**ADC Planning Consultation
Conservation/Design Officer Response**

Application Number	LU/390/17/PL
Address	Littlehampton Covered Market 26-28 Surrey Street Littlehampton BN17 5BG
Description	Demolition of existing building & erection of 1 No. retail unit & 3 No. flats above with associated external works & access. This application may affect the setting of Listed Buildings & the character & appearance of the Littlehampton (River Road) Conservation Area.
Case Officer	<u>Mrs A Gardner</u>
Date	24 th January 2018

- Notes
1. This drawing is the copyright of MH Architects Ltd
 2. Do not scale this drawing except for Local Authority planning purposes
 3. All dimensions must be checked on site by the contractor prior to commencement of the works.

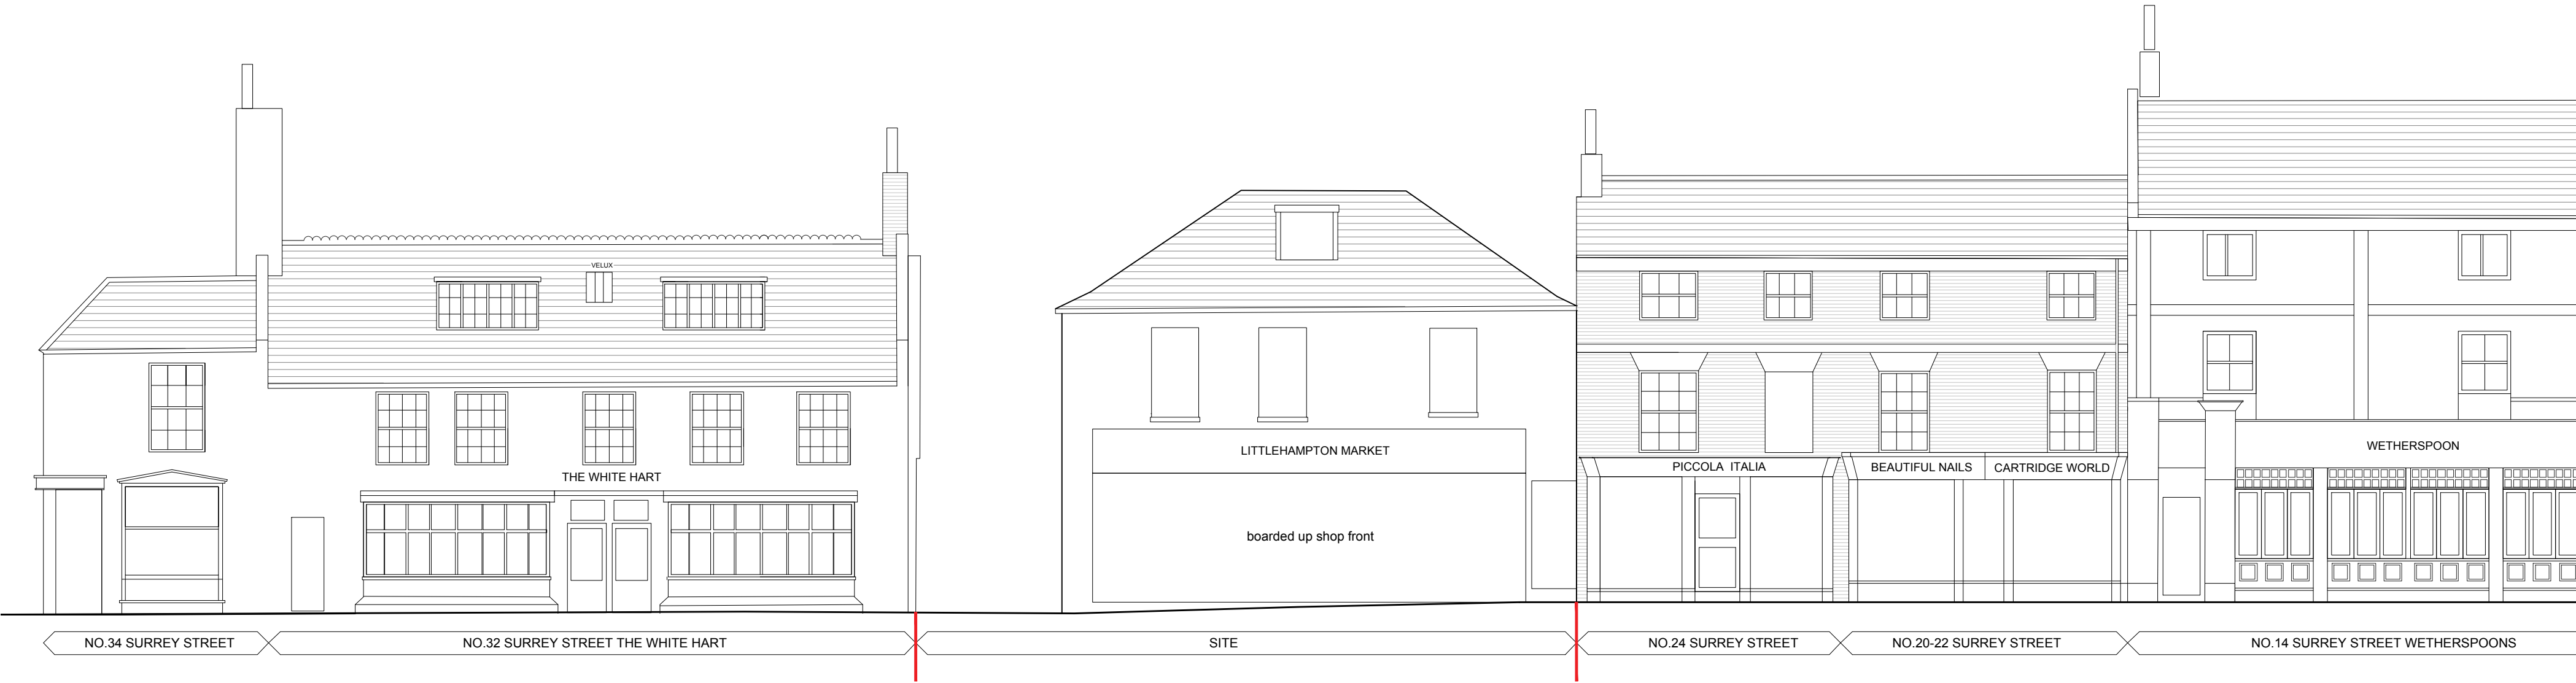
The proposed demolition is regrettable as the existing is a characterful four-square, flint walled structure under a slate roof.

Proposed Plans And Elevations

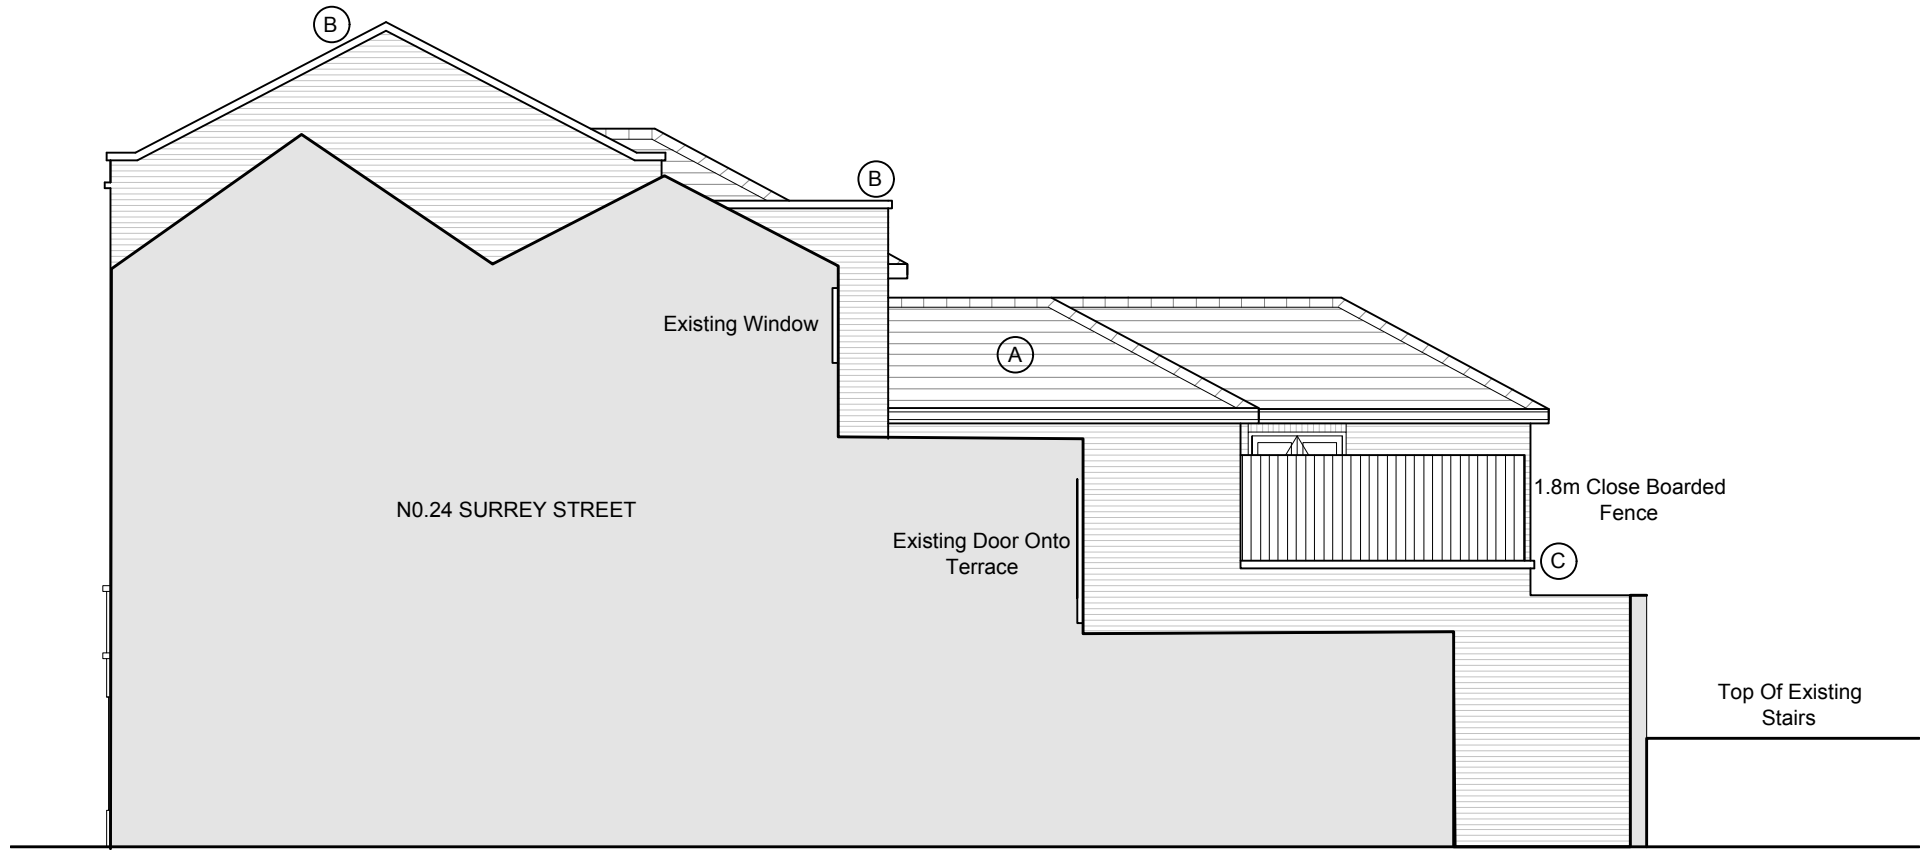
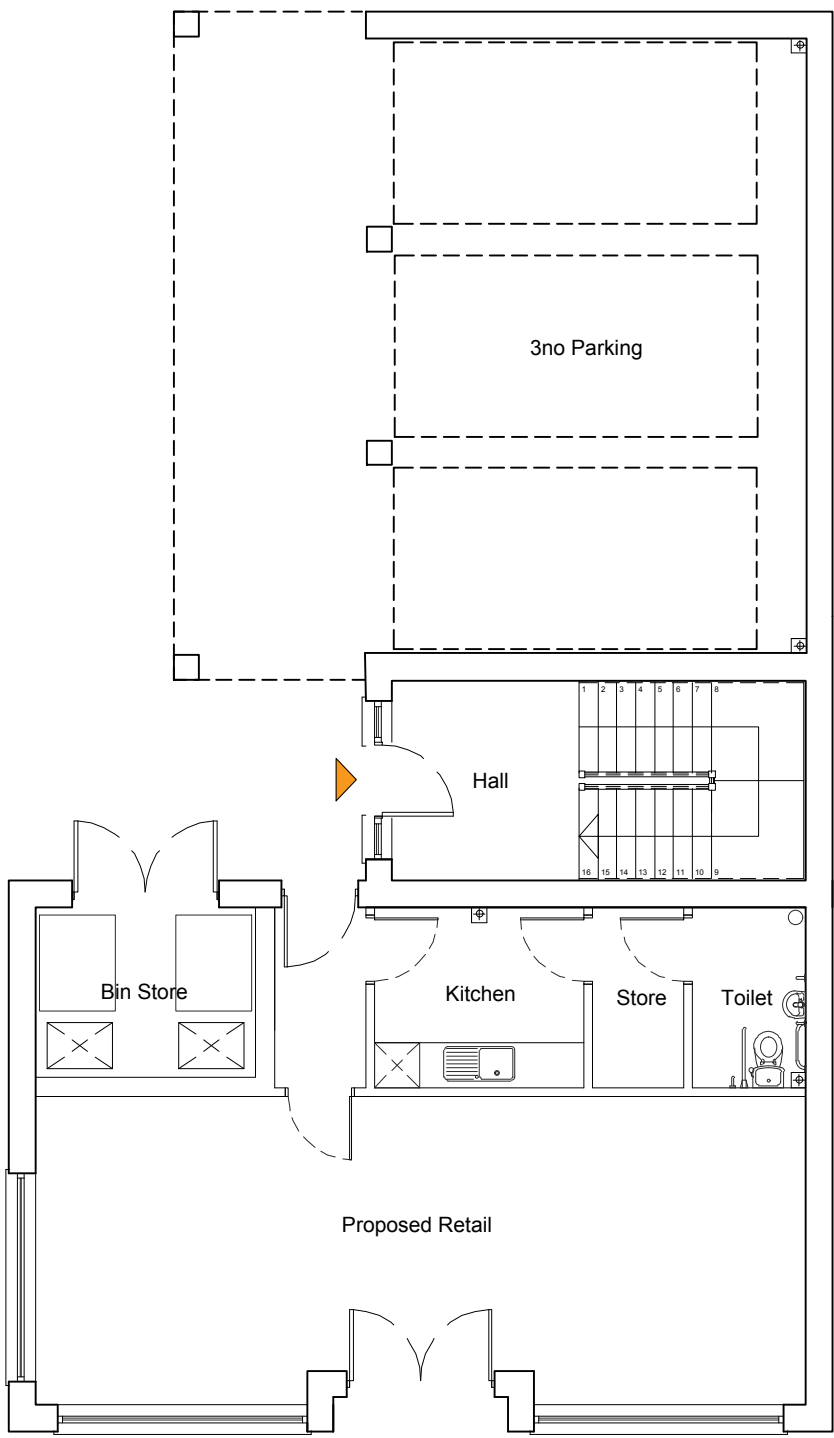
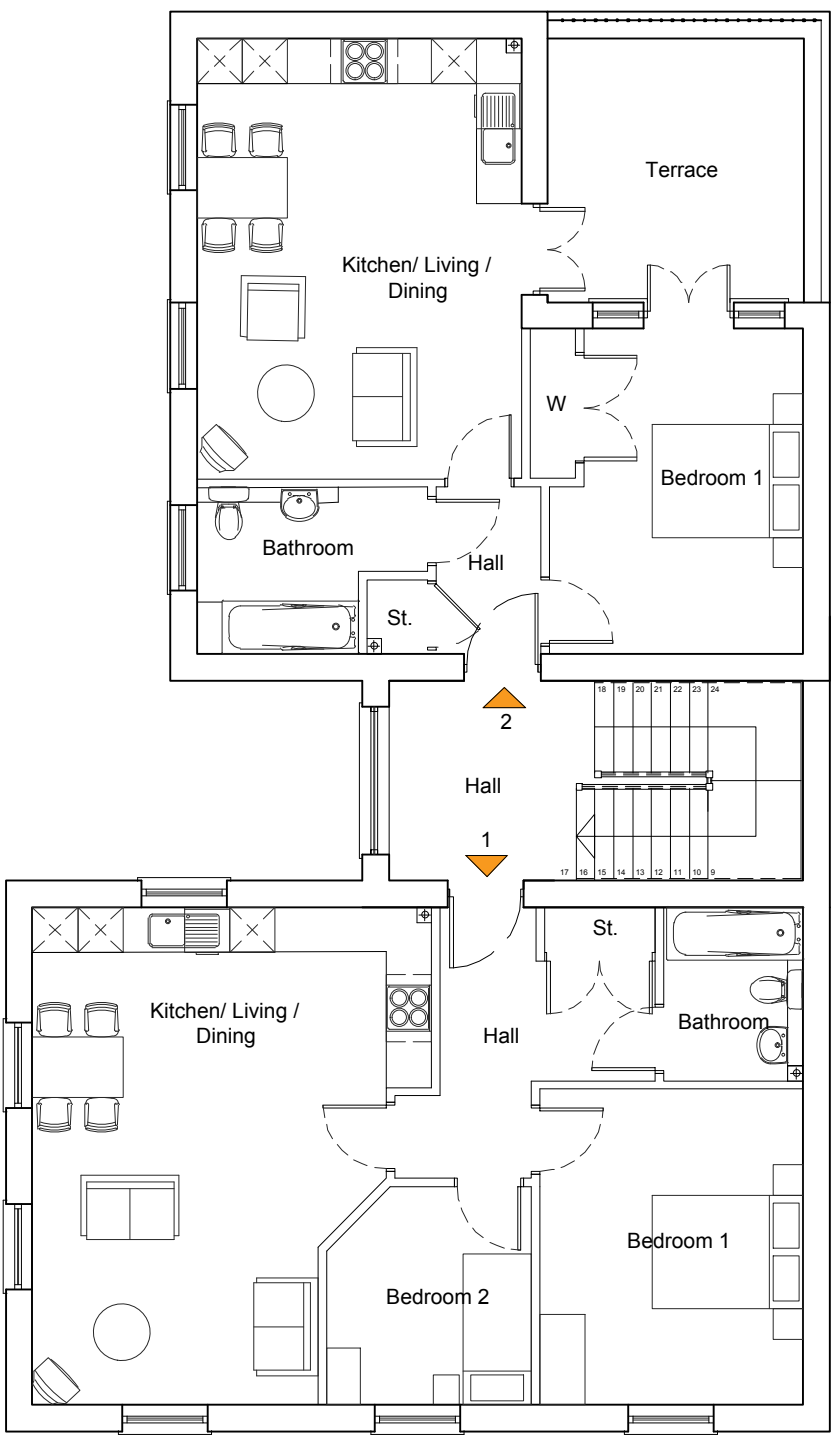
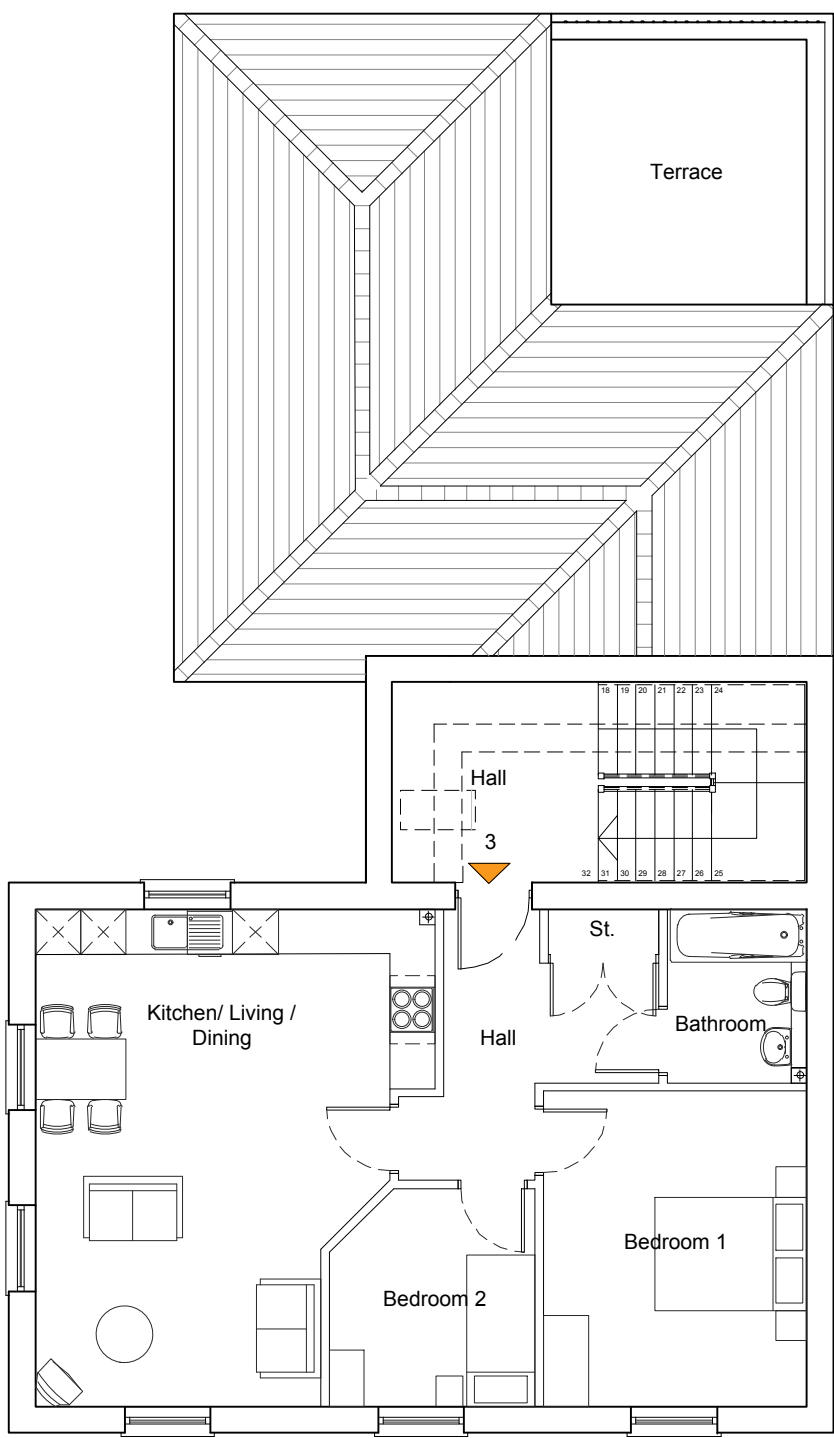
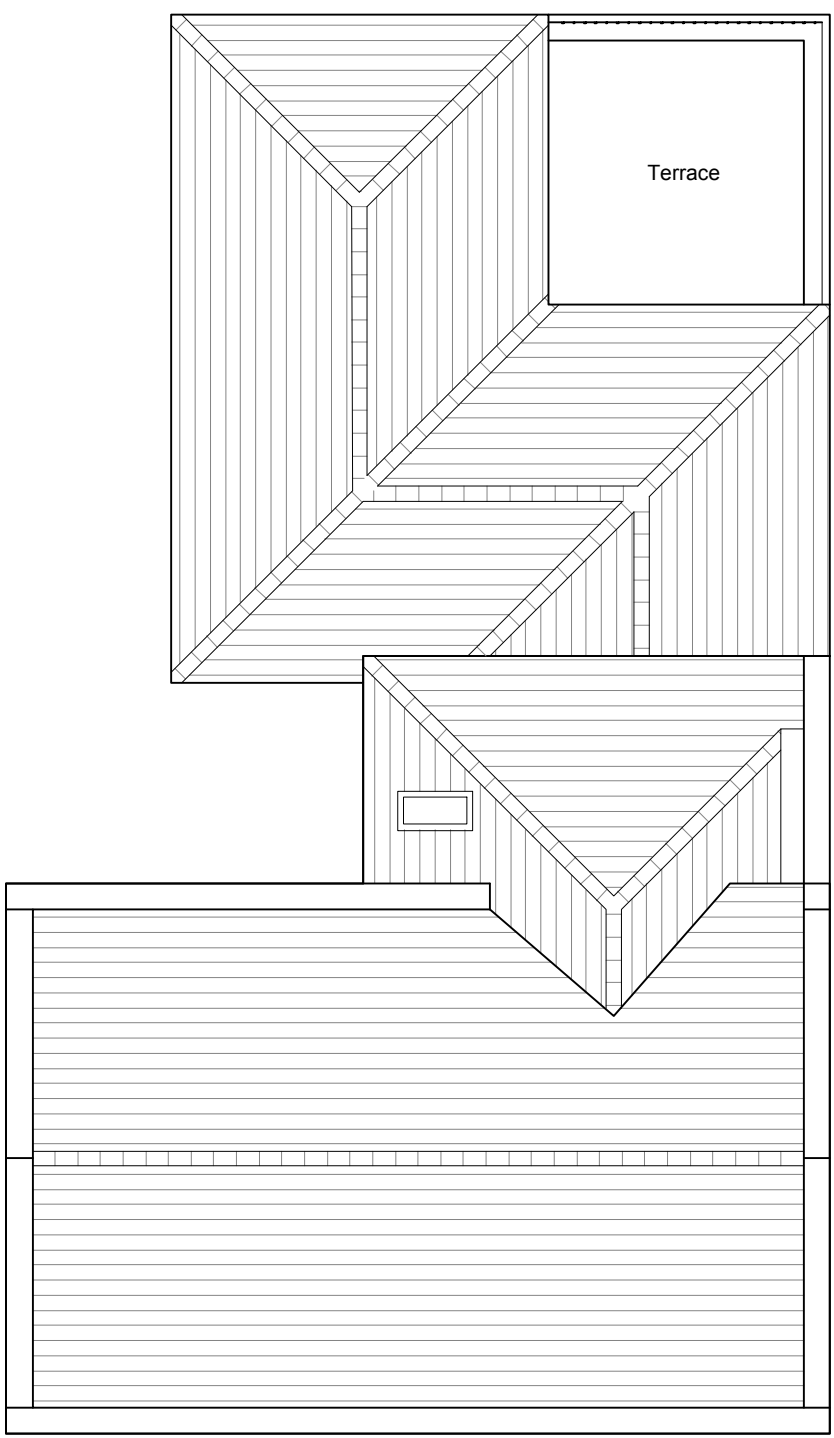
It is considered that the proposal is overly dominating in scale and ridge height, and does not respond to the natural rise of the topography up Surrey Street. The effect of the proposed would be to interrupt the existing sequential rise in ridge height of buildings travelling up Surrey Street.

It is considered that the proposed materials are of insufficient quality (where specified), given the sensitive setting. In particular, the proposed 'white sash effect windows' are of insufficient quality and 'false slate tiles' as a roofing material. Other materials are not sufficiently specified to make further comment.
